# Rezoning Transportation Analysis

Petition Number: 2020-011

Date	Description
02-18-2020	First Review

MARGARET WALLACE SUBDIVISION
 CHARLOTTE, NORTH CAROLINA
REZONING SITE PLAN

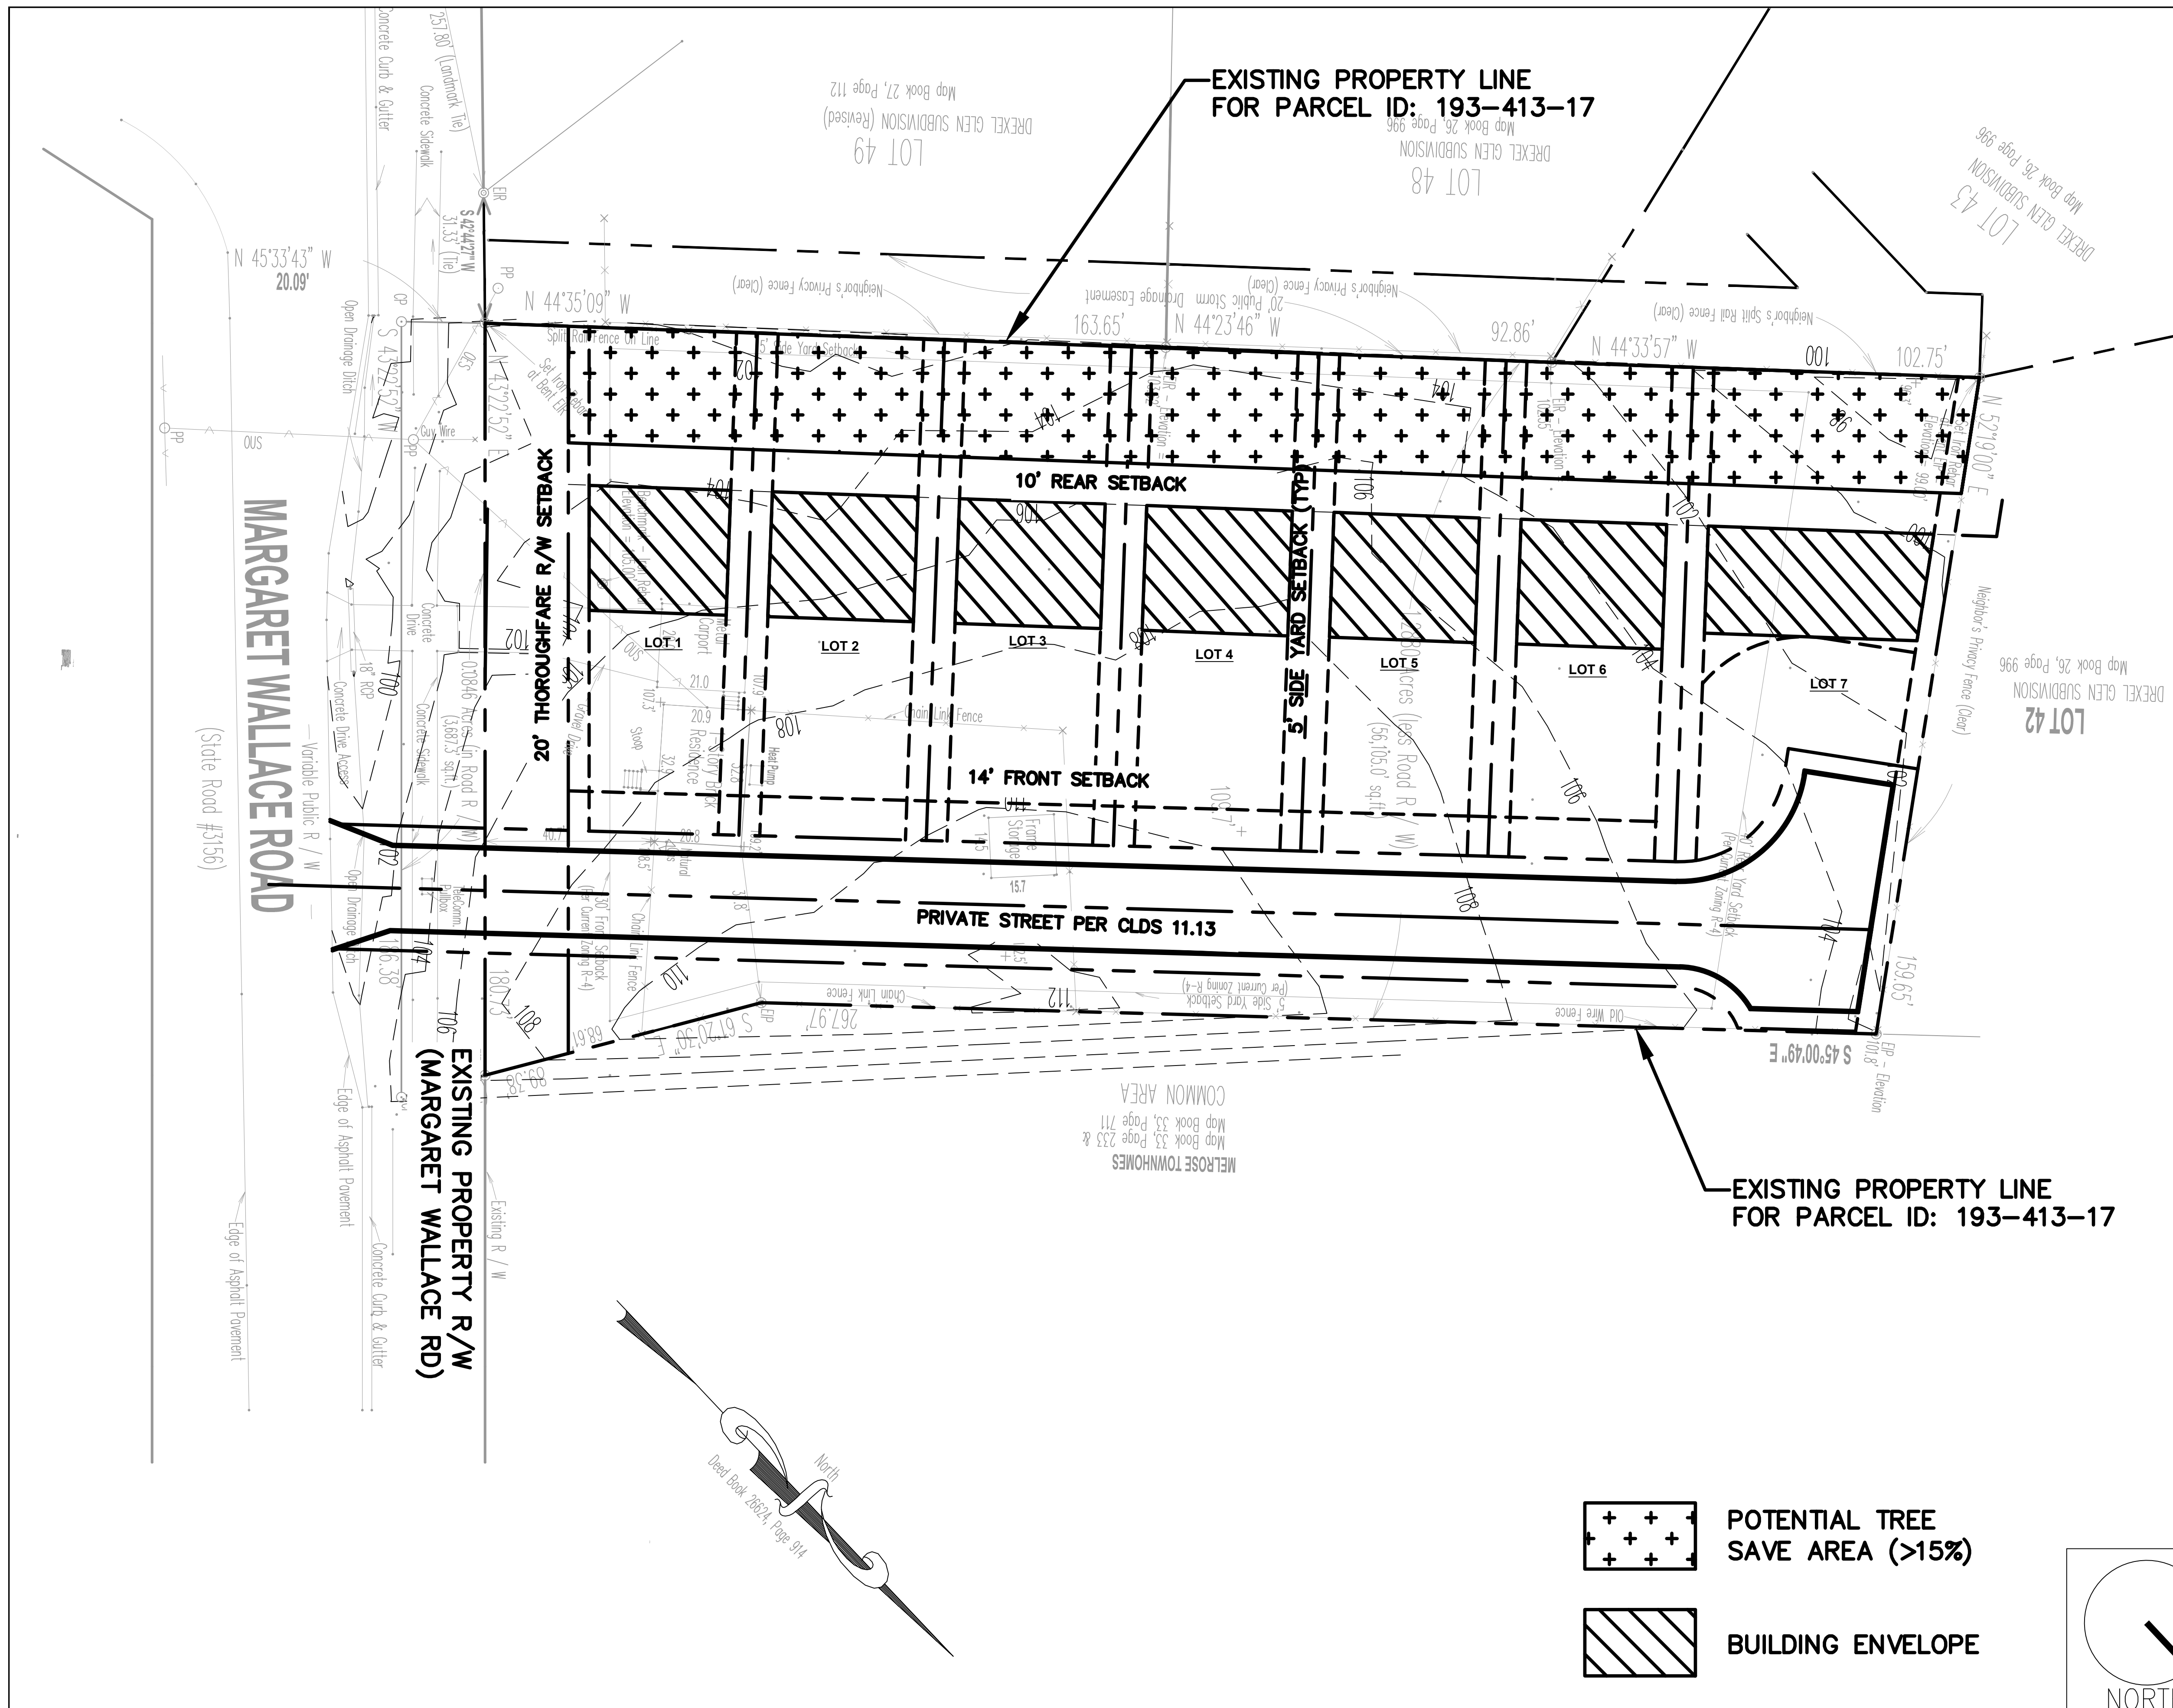
The site is located on a major thoroughfare road. The petitioner should update the site plan to meet Chapter 19<sup>th</sup> curb and gutter requirement of curb and gutter and sidewalk along the site's frontage. In addition, the petitioner should provide a left-turn into their access due to large trips on Margaret Wallace Road.

1. **Curbline** The proposed zoning district has a setback measured from back of the existing or proposed future curbline.
  - a. **Margaret Wallace Road:** Location of future back of curb and gutter needs to be constructed 33' from centerline.

The site plan should show the curb and gutter labeled and dimensioned from the centerline for each road.

3. The petitioner should revise the site plan and add a conditional note to commit to dedicate 50' right-of-way from the road centerline to meet CRTPO guidelines for R/W on a major thoroughfare. The site plan should label and dimension the right-of-way from the road centerline.

4. The petitioner should revise the site plan and conditional note(s) to construct the "private street" to meet USDG standards per the subdivision ordinance. CLDS U-03A

5. The petitioner should revise the site plan and conditional note(s) to construct an 8' planting strip and 6' sidewalk behind the curb and gutter to be installed.

6. CDOT is requesting the petitioner revise the site plan and conditional note(s) to connect to existing sidewalk and extend to Glen Lyon Drive to complete the pedestrian infrastructure for this block and help with meeting the City Council Adopted Charlotte Walks Policy.

7. The petitioner should revise the site plan and conditional note(s) to add a left turn lane into the proposed street connection of the site.
8. The petitioner should revise the site plan to add a note specifying dedication and fee simple conveyance of all rights of way to the City before the site's first building certificate of occupancy is issued. CDOT requests right of way set at 2' behind back of sidewalk where feasible.
9. ~~The petitioner should revise the site plan to add a note specifying all transportation improvements will be approved and constructed before the site's first building certificate of occupancy is issued. The petitioner may phase transportation improvements if said improvements and phasing are explicitly described in site plan notes.~~
10. ~~Resolved~~ Sample format for comment that is resolved
